SPR EA1N and EA2 PROJECTS

DEADLINE 10 - ADDENDUM TO SASES

DEADLINE 9 SUBMISSION ON SUBSTATION DESIGN PRINCIPLES STATEMENT

Interested Party: SASES PINS Refs: 20024106 & 20024110

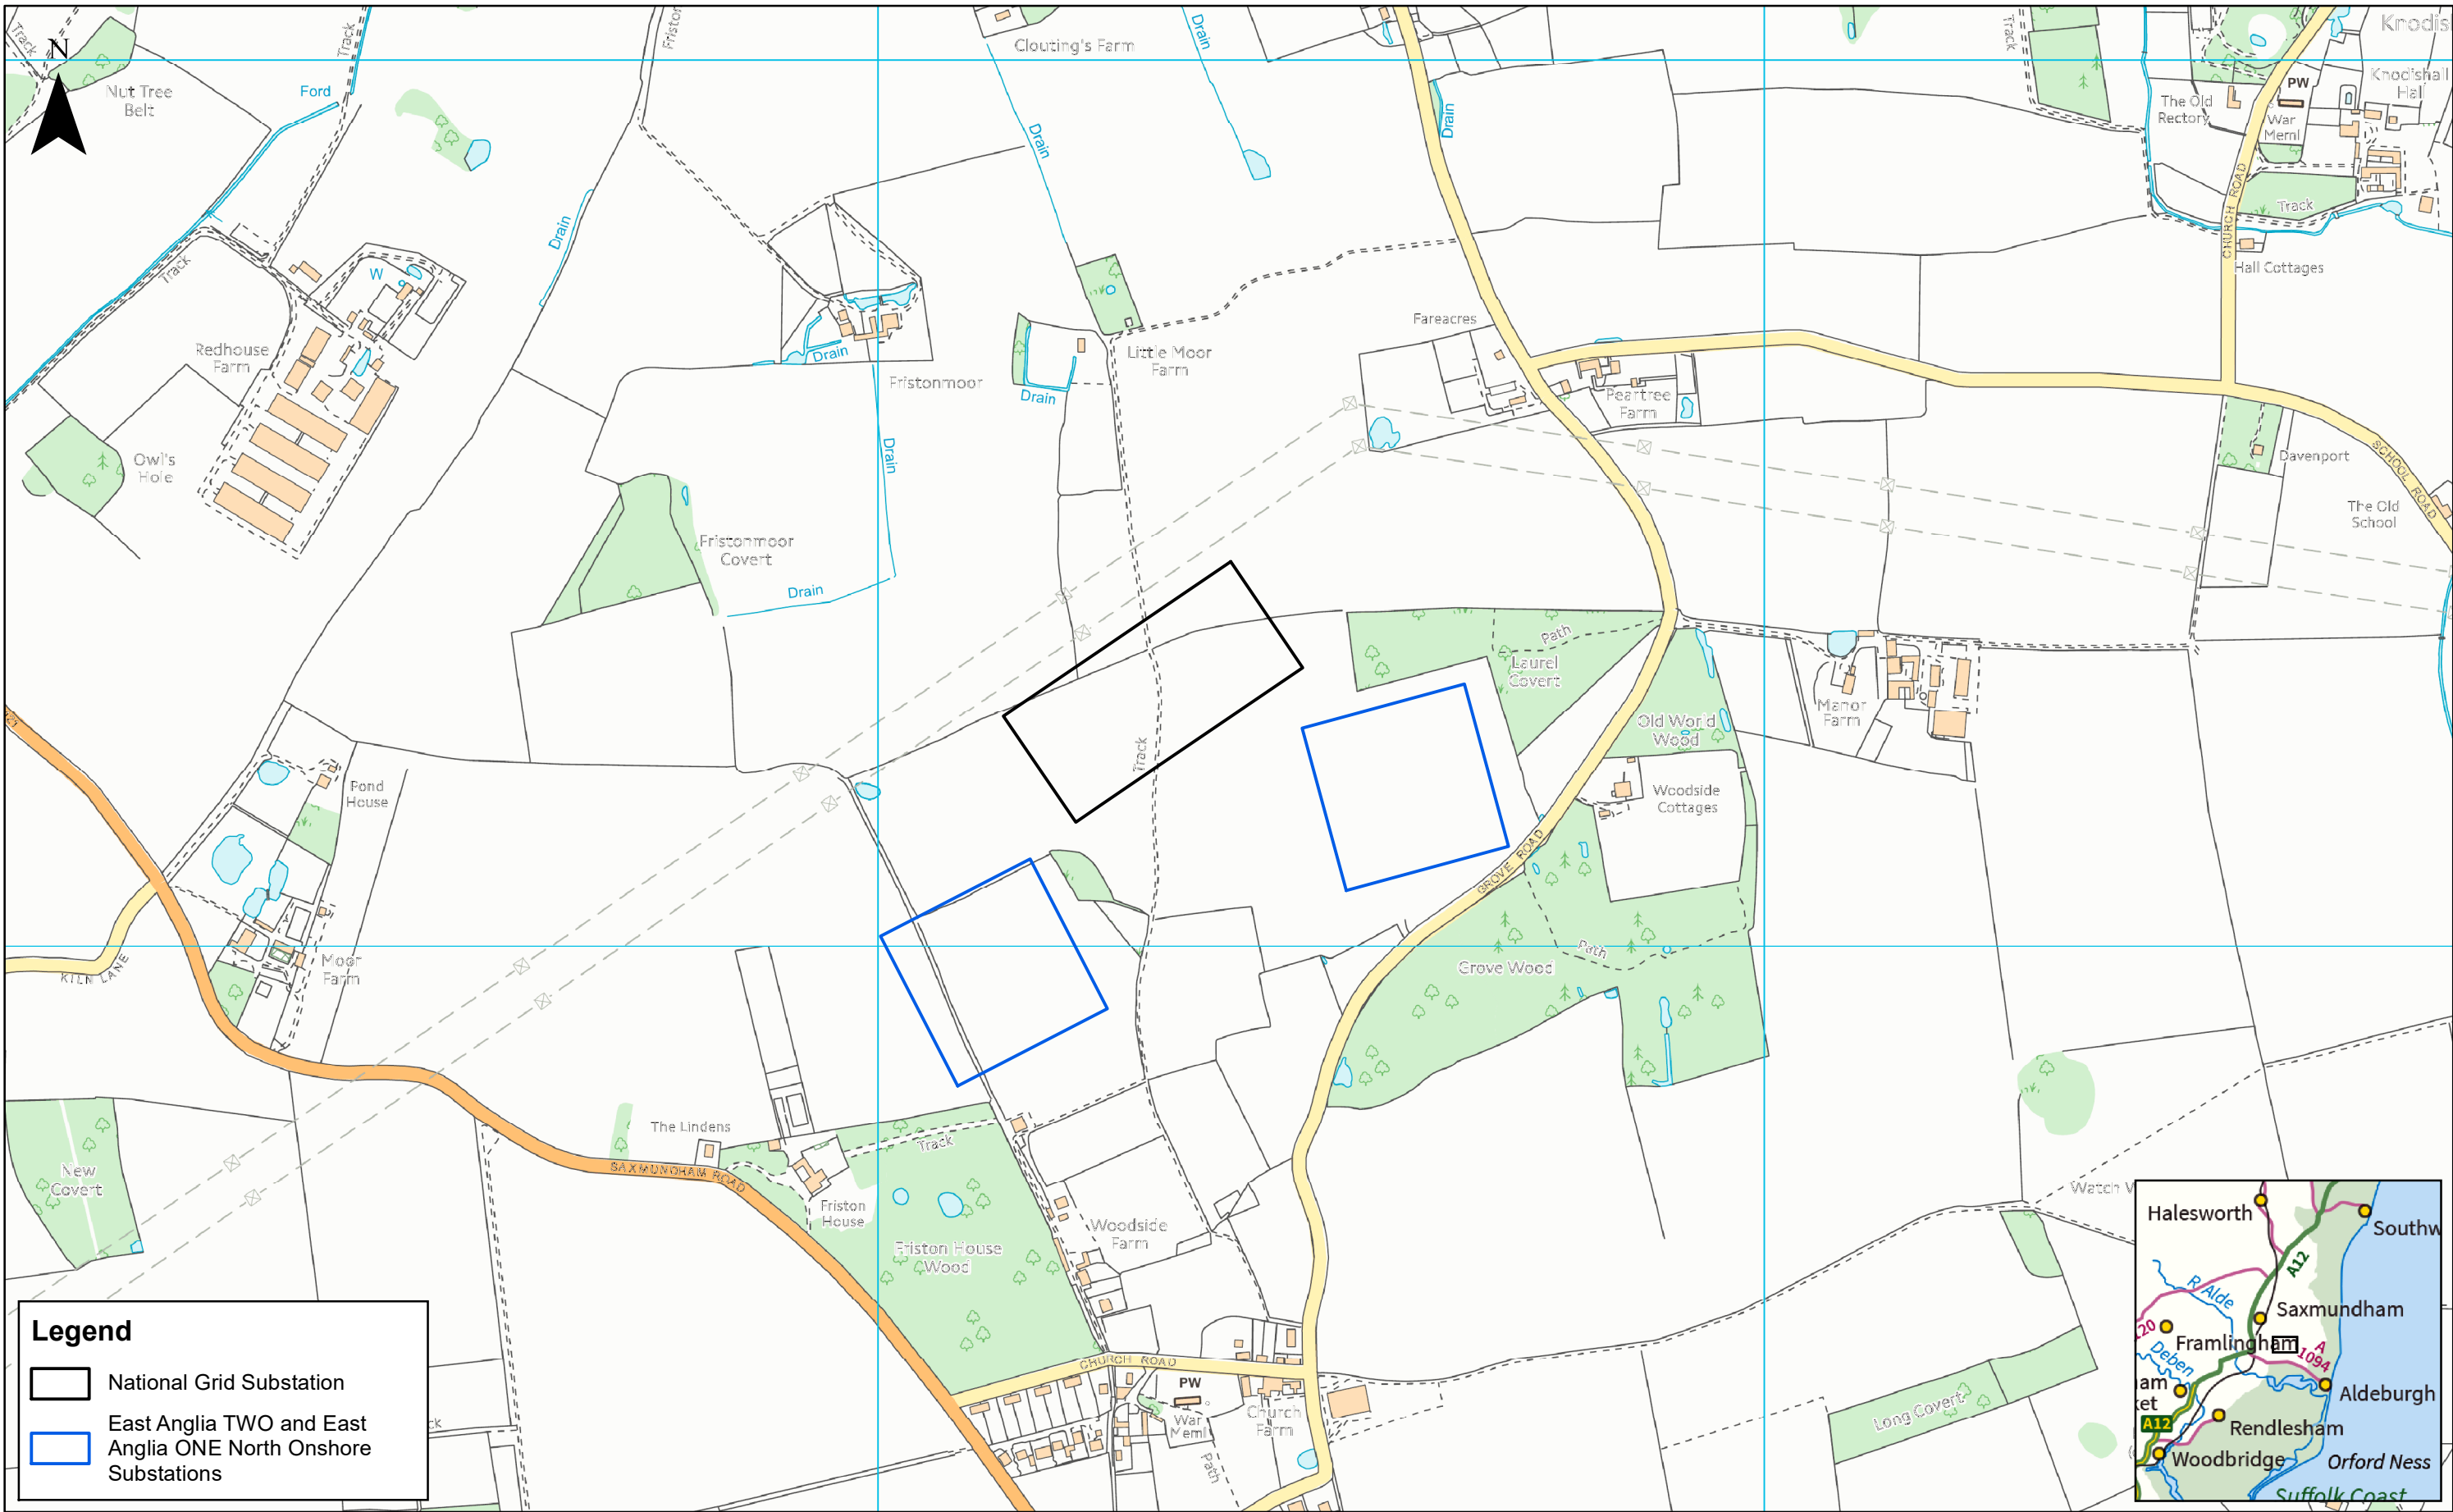
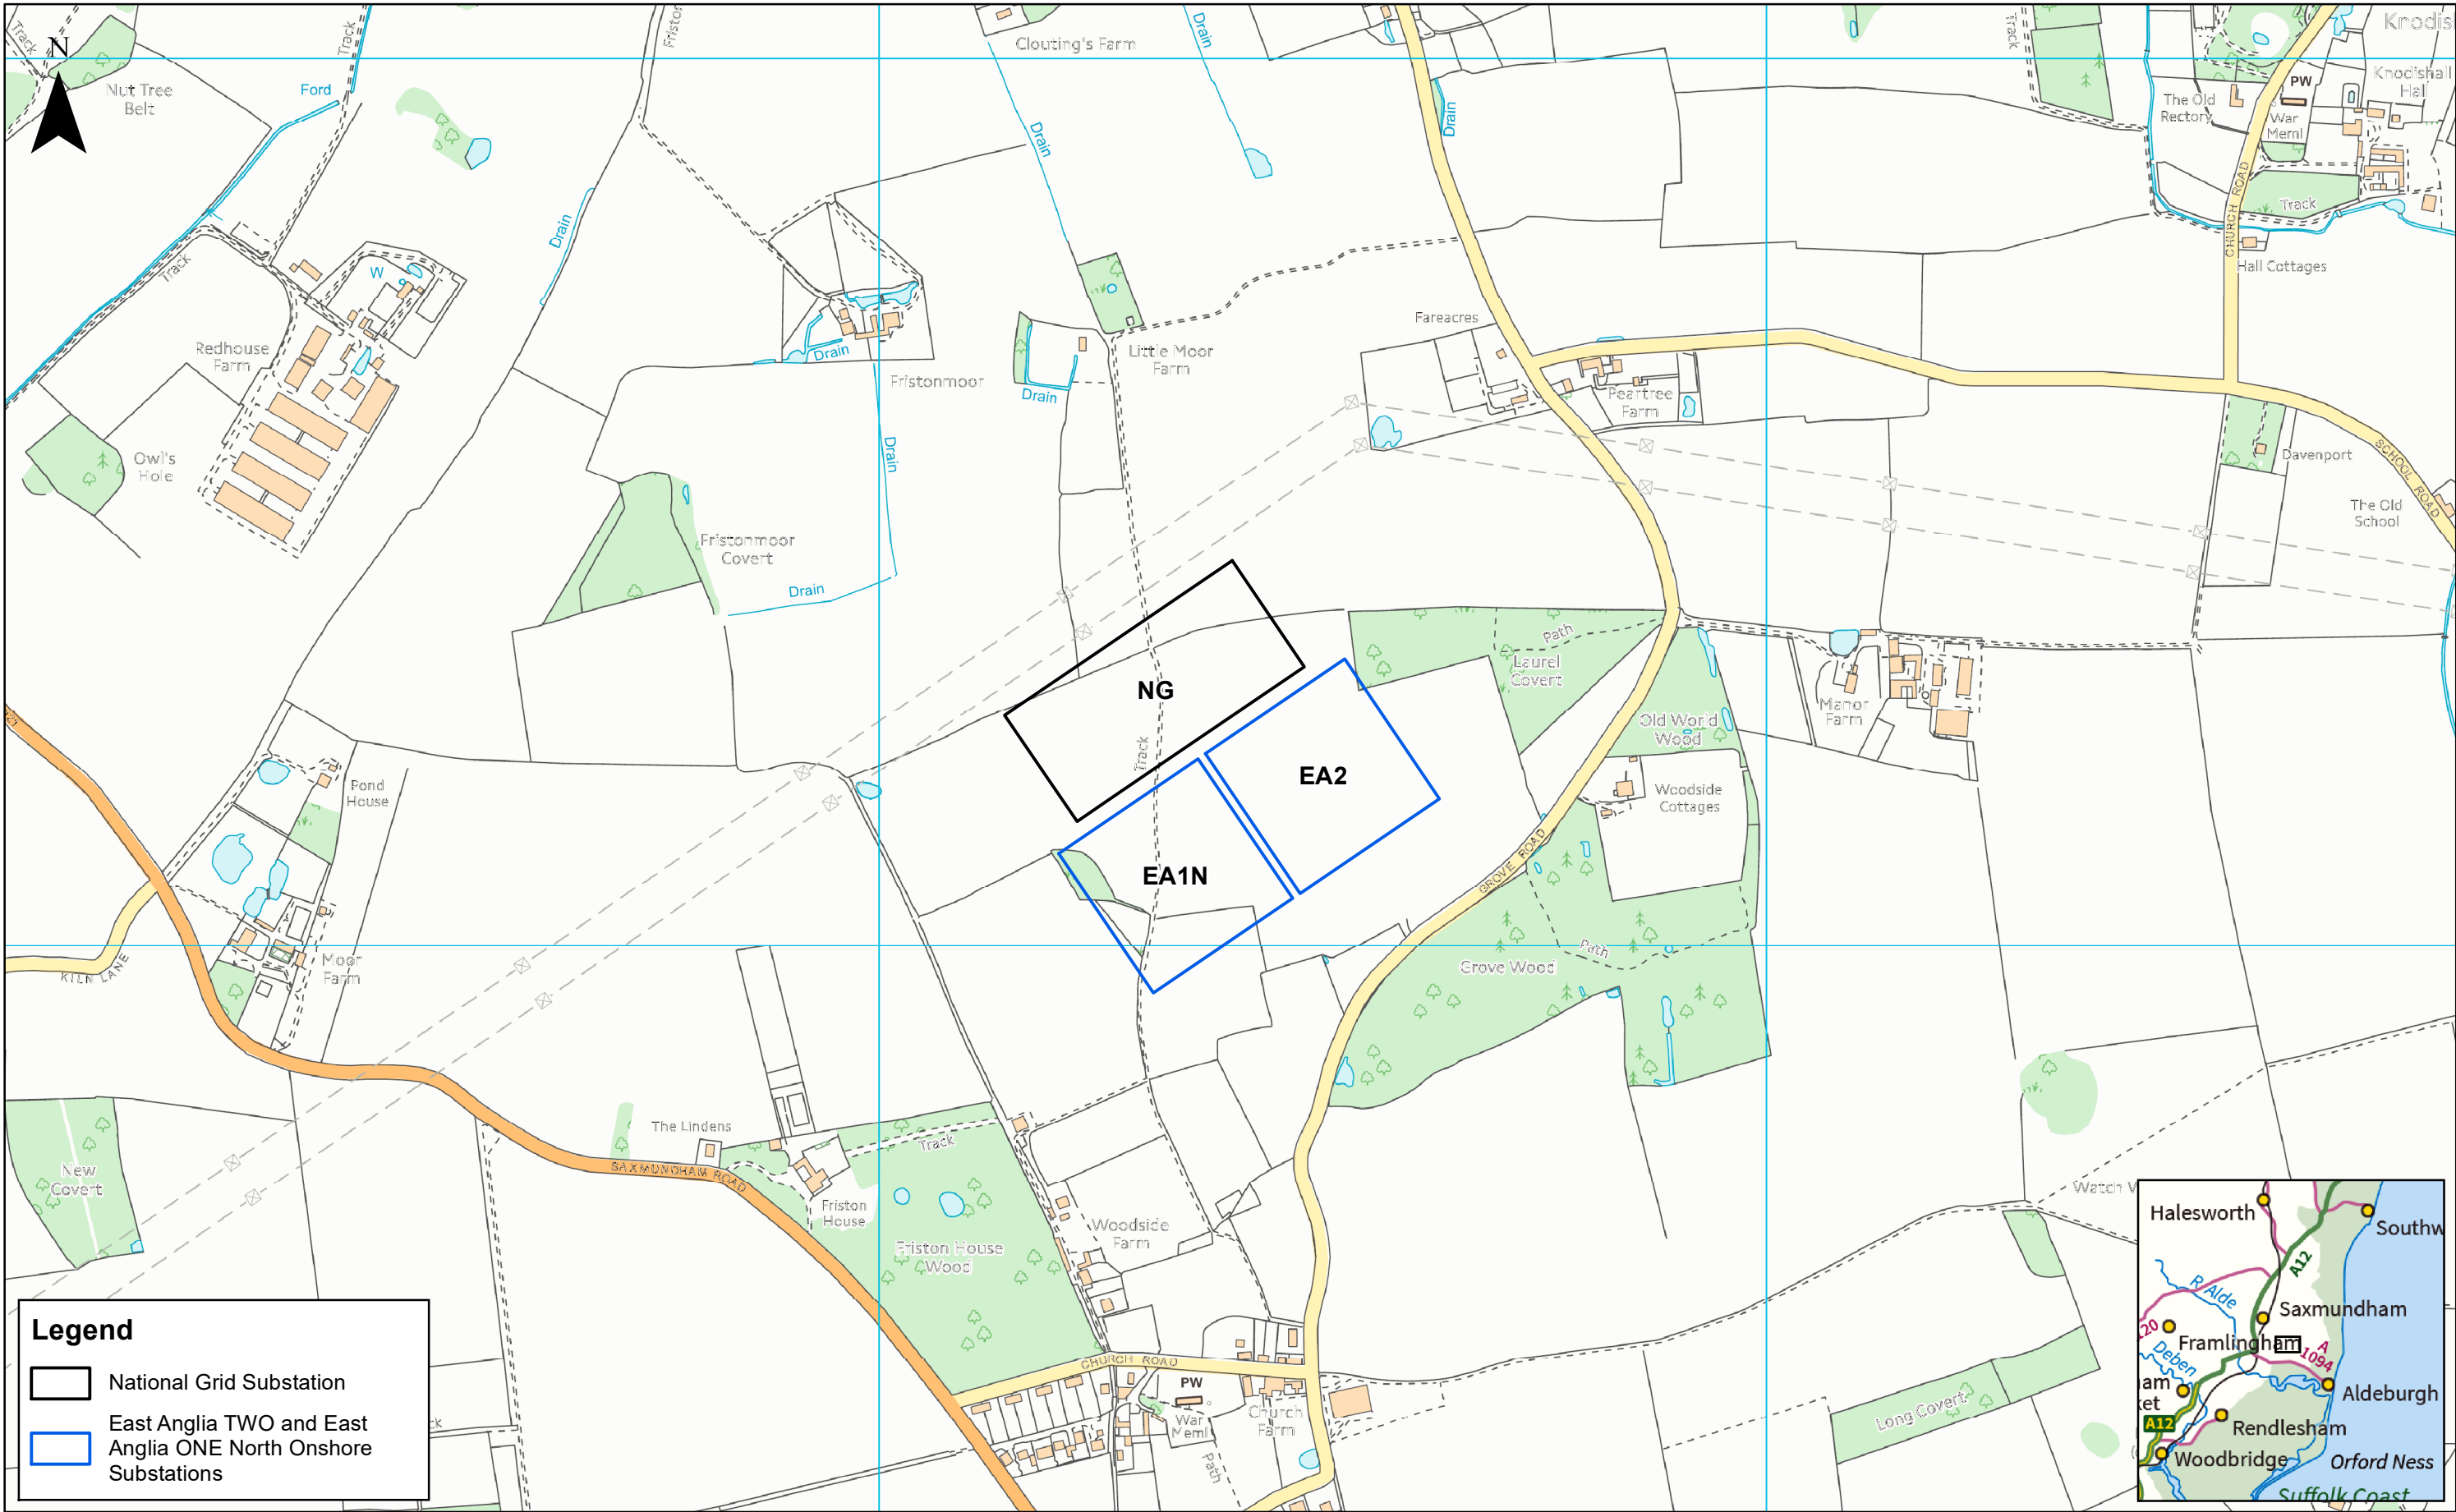
Paragraph 3.2 of [\[REP9-078\]](#) addresses the issue of the unacceptable height of the capacitor banks associated with the Harmonic Filters for the proposed Applicant’s substations.

Following enquiries of well-established suppliers of such equipment, asking whether it would be possible for the proposed 14m high 275kV capacitor banks to be split into pairs of lower height, the following response has been received from a major supplier:

Based on this information SASES reaffirms its belief that the current substation design proposal does not meet “Good Design” criteria and that the Applicant should offer a much improved design with a smaller footprint and overall lower height, with a proposed target of 10m height for all buildings and equipment.
